RE: 2025/92388 (JCNAS 209837) | Red House Museum, 281 Oxford Road, Gomersal, BD19 4JP (Grade II*, c.1660, with C18, C19 and C20 alterations). Application for subdivision into two residential units and conversion of barn and coach house into third residential unit.

Thank you for consulting the Victorian Society on this application. Having considered the proposal carefully, we **raise serious concerns** to these plans in their current form.

Drawing title
**Red House
Ground Floor Plan as Proposed**

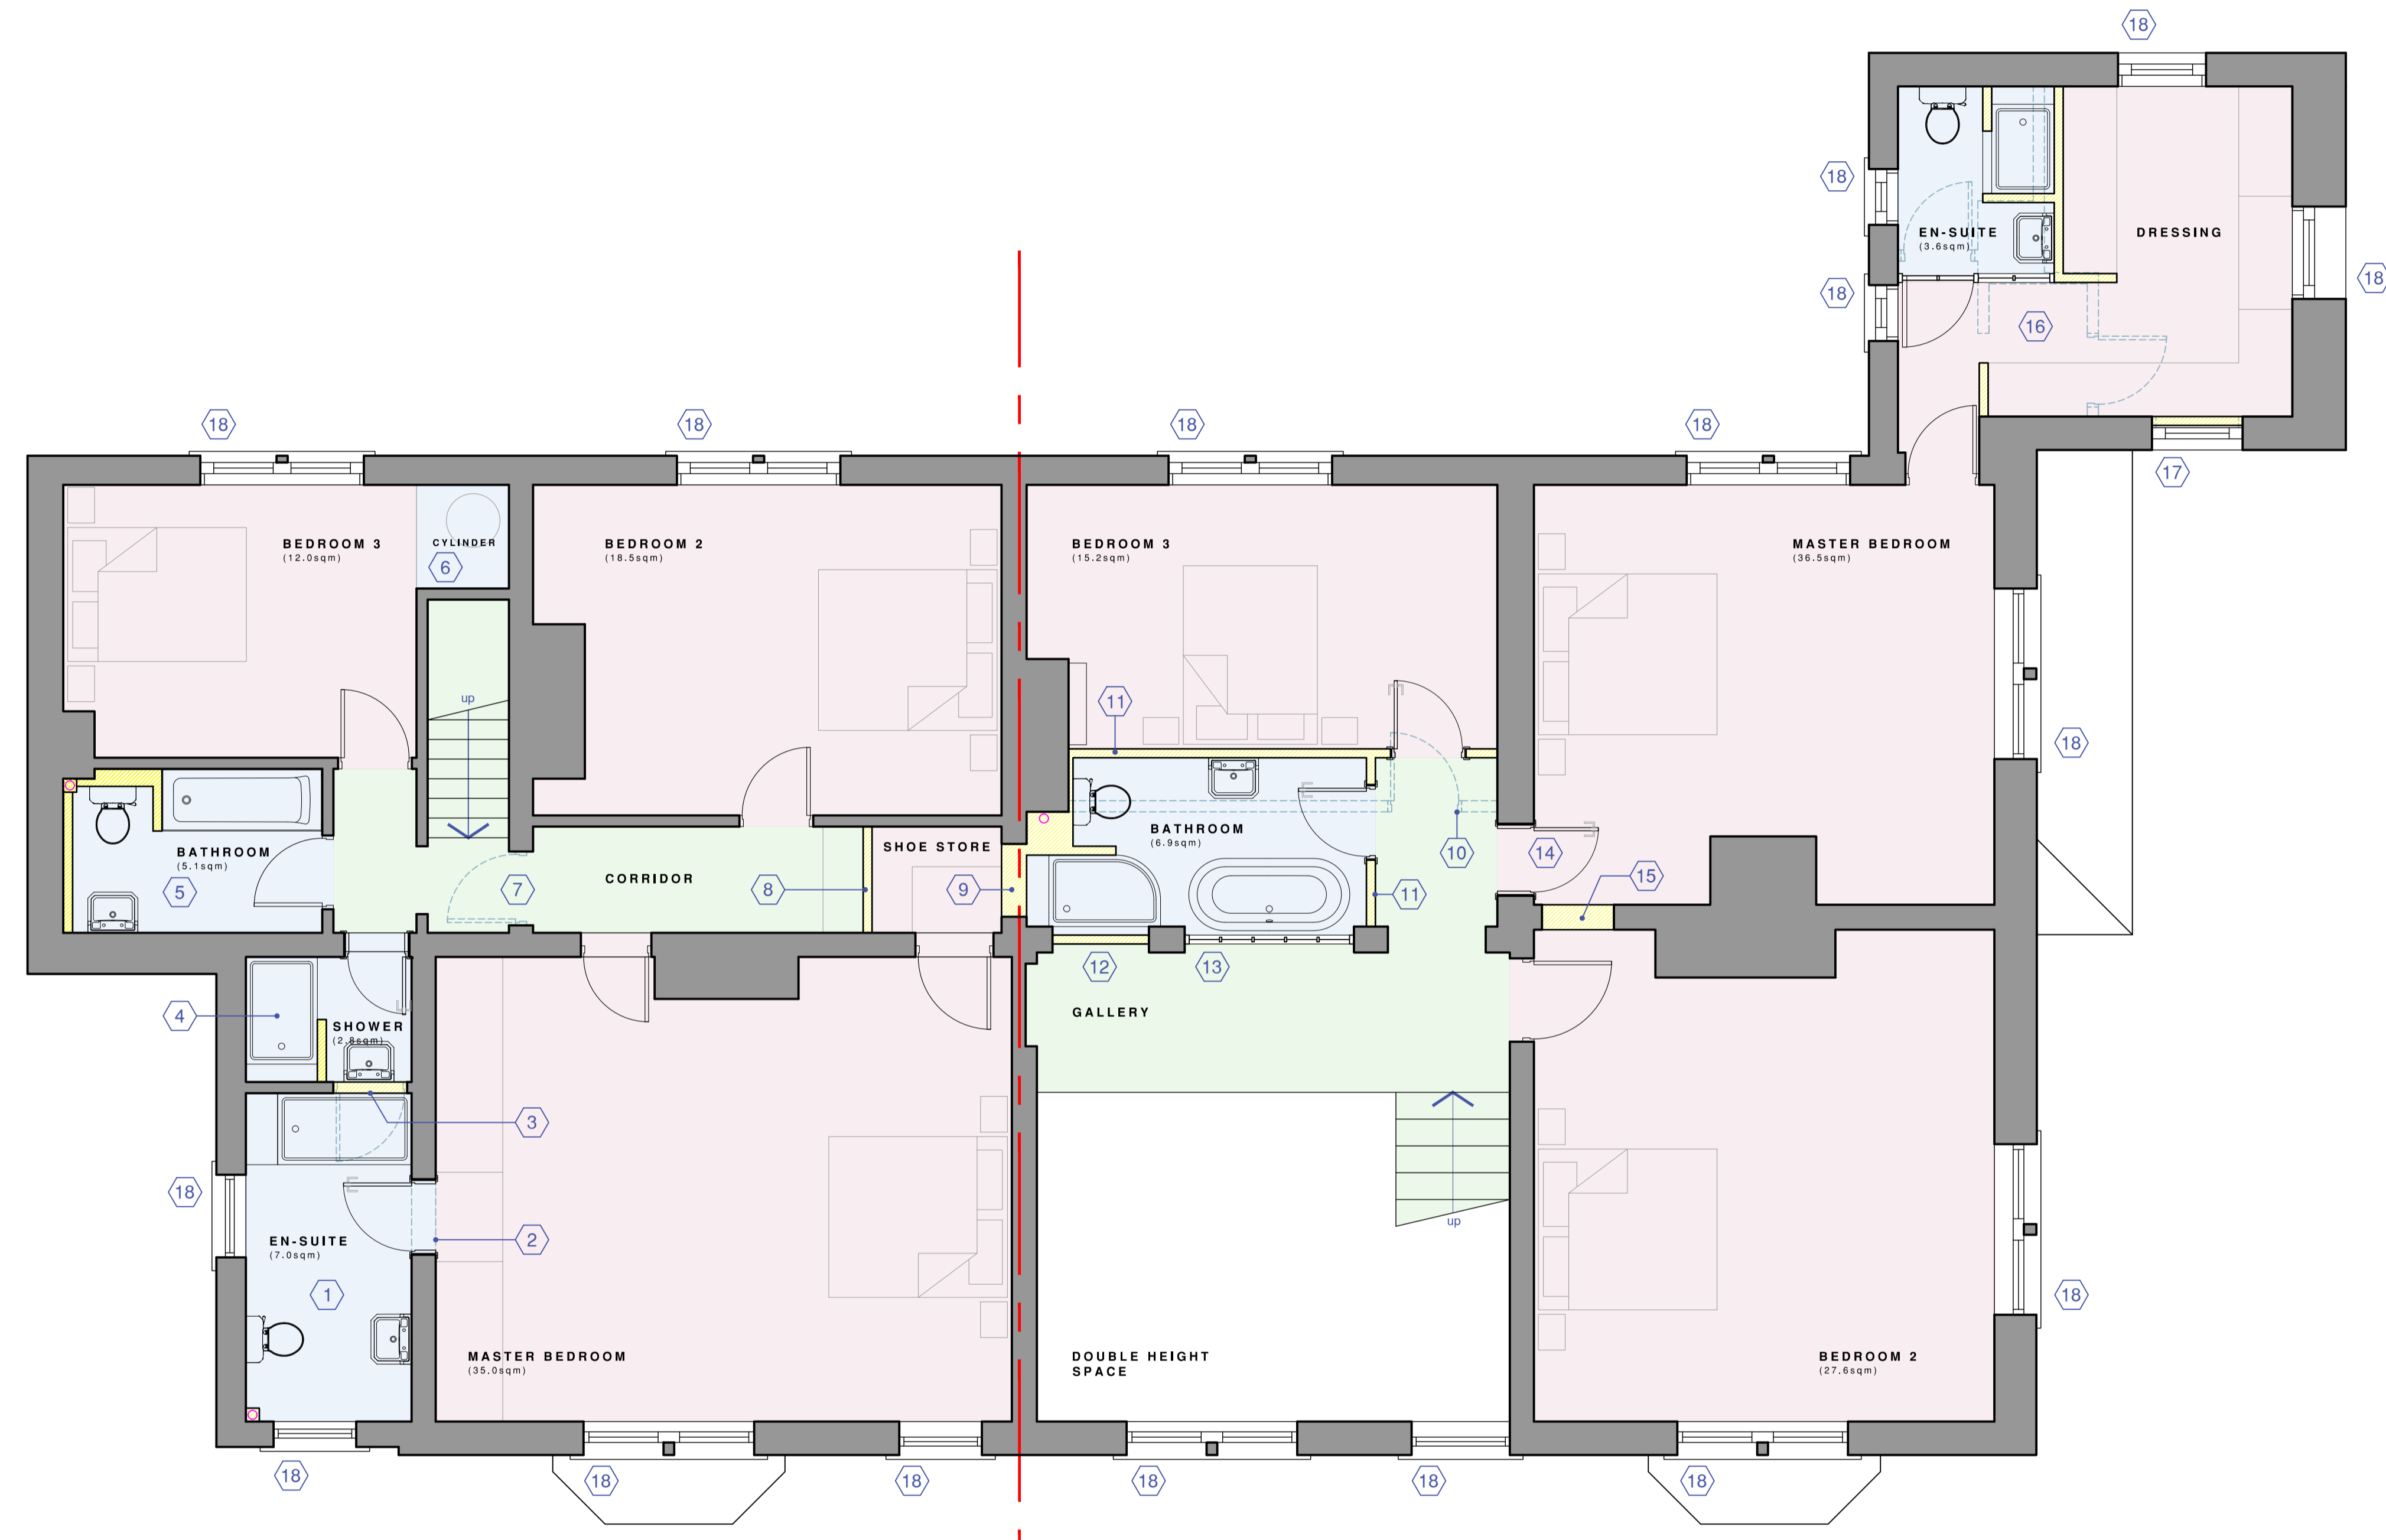
The Society is concerned that the division of the house into two separate dwellings will cause harm to the historic planform of the building. Historically, this has been one property and the lived experience of this building reflects this use. To close off hallways, rooms and doorways would disrupt the flow of the building, change access routes and alter how the building is understood as an historic asset. We recognise that the change of use from museum to residential is a reasonable proposal for this building. However, we remain concerned that the splitting of the property will have a negative effect the significance of the Grade II* listing.

The subdivision of space is also a cause for concern for the Society, and we question the need for the creation of lobbies and hallways where not already present. The core of the building dates to before the corridor was a common feature in domestic architecture, and the ground floor planform reflects this historic aspect. It would appear little change has occurred in this space in regard to plan form. The first floor would appear to be historically altered in the C19th and has a corridor, thus further subdivision here is less harmful and limited to the creation of bathrooms. Any change here must be very carefully justified.
